Our ref: DOC22/630599
Your ref: SSD 38600121

Subject: EHG Comments on the Environmental Impact Statement for Alexandria Health Centre 38-32 Bourke Road, Alexandria (SSD-38600121)

Attachment A – EHG comments and recommendations on the Environmental Impact Statement for Alexandria Health Centre 38-32 Bourke Road, Alexandria (SSD-38600121)

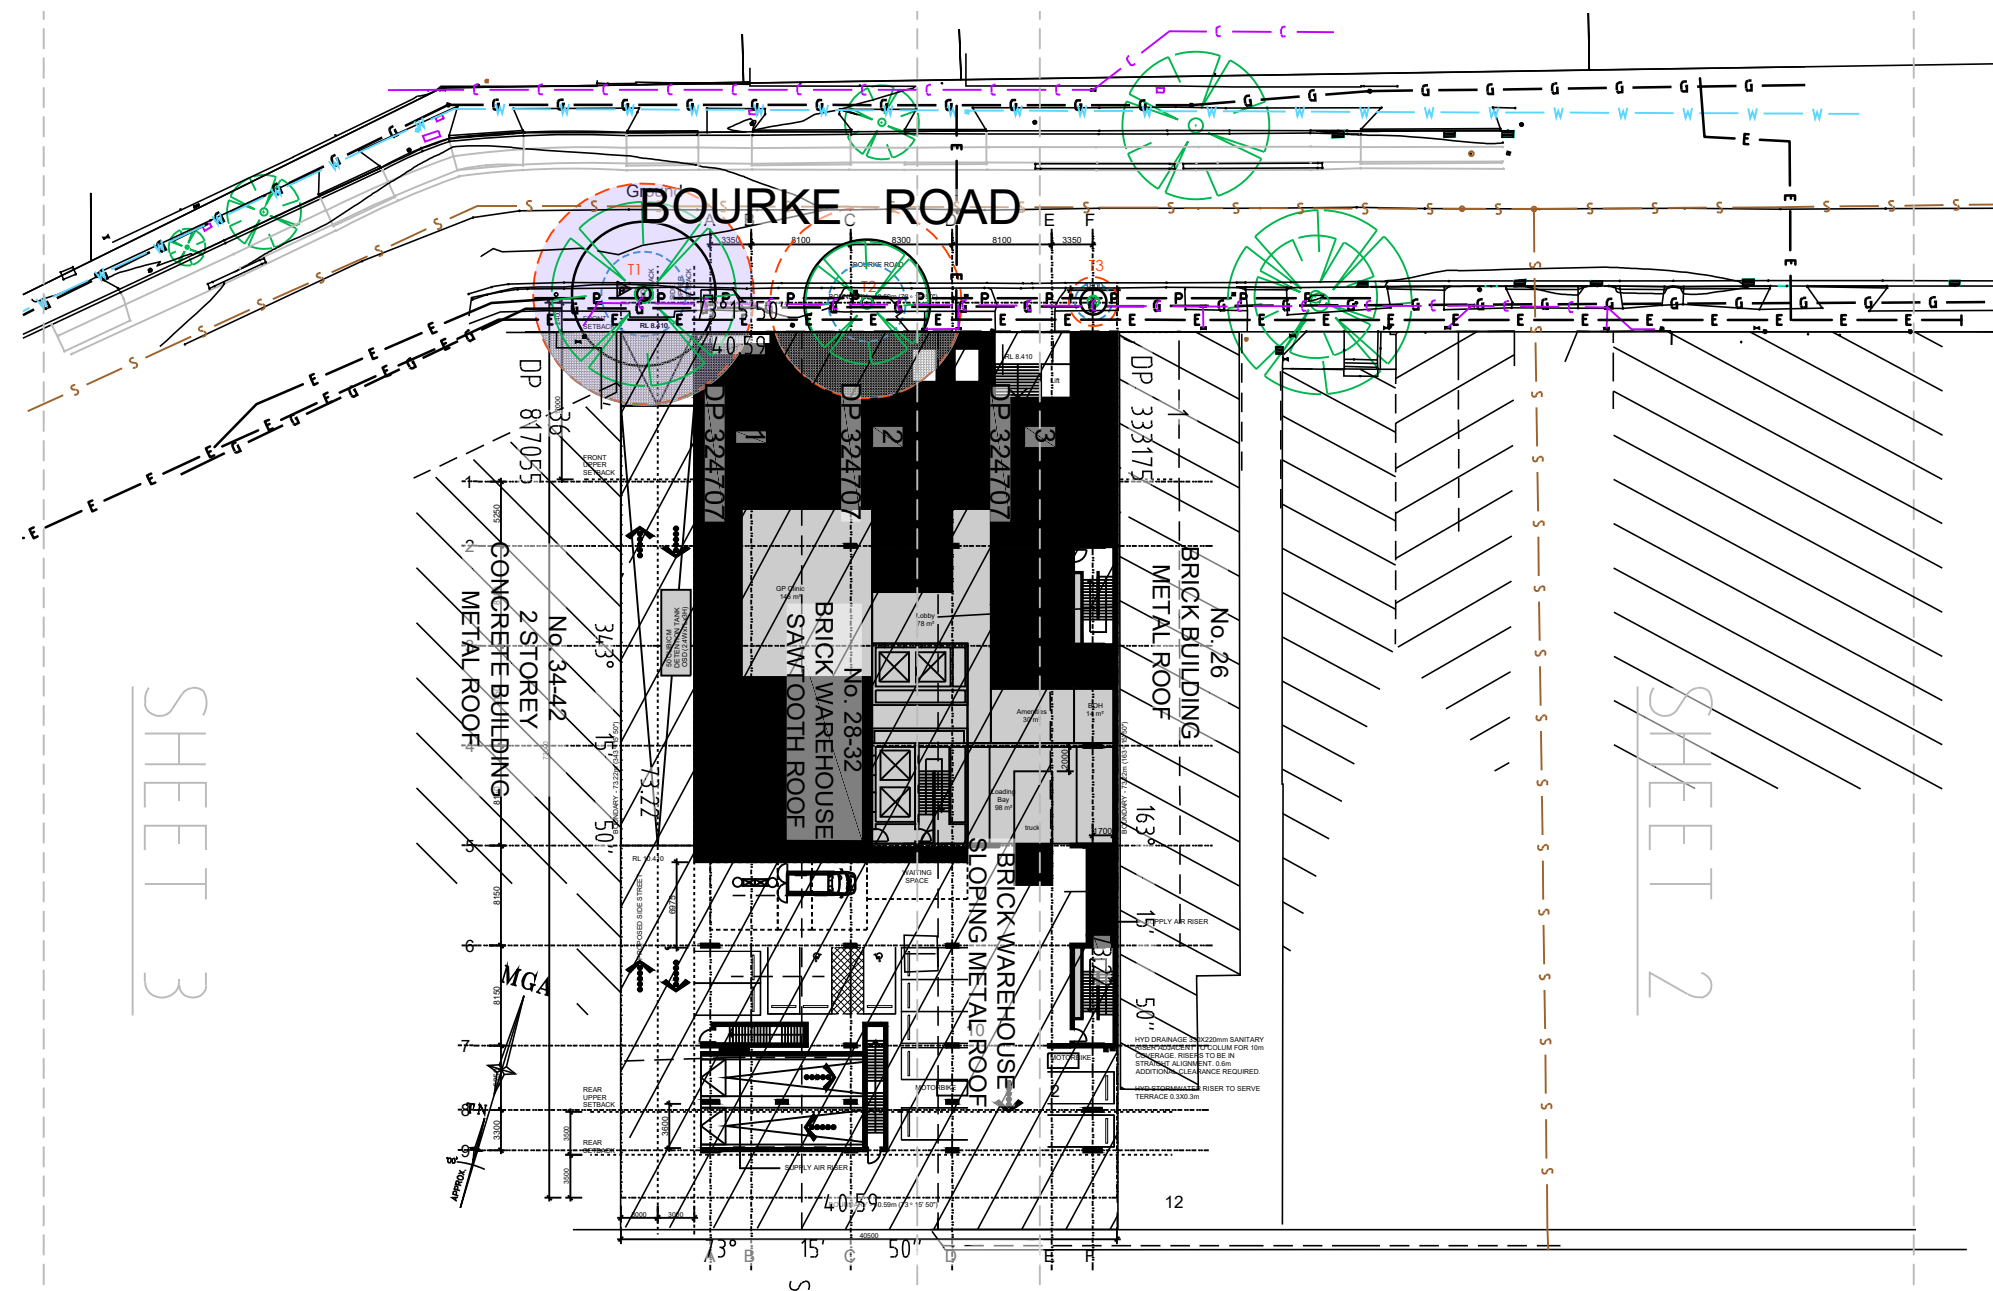
- In relation to Tree 2 the AIA advises that this tree will be subject to minor pruning works to provide clearance of the proposed building. Noting that submitted plans indicate that the area adjacent to Tree 2 will consist of a Deep Soil Area where new trees will be planted it is unclear as to why Tree 2 needs to be pruned.

- The AIA (Table 7) advises that the new building encroaches on Tree 2 up to 31.5%. It is noted that the encroachments to Tree 2 will be associated with footpath widening, demolition of the existing building, land remediation works and possibly by stormwater management infrastructure and new services as opposed to the footprint of the new building. EHG therefore recommends that the submitted AIA is amended to reflect this.

- The AIA does not advise if Tree 2 can survive a major encroachment of up to 31.5% as well as an unspecified encroachment to its mapped SRZ. EHG recommends that further clarification is required on this matter.

- The Tree Location Plan in the AIA should be updated to include the indicative location of Tree Protection Fencing and Trunk battens. The Landscape Report prepared by Place Design Group Dated 6 July 2022 indicates that four new trees (*Eleocharpus eumundi*) will be planted on the development site to mitigate the loss of Tree 1. It is currently unclear as to what
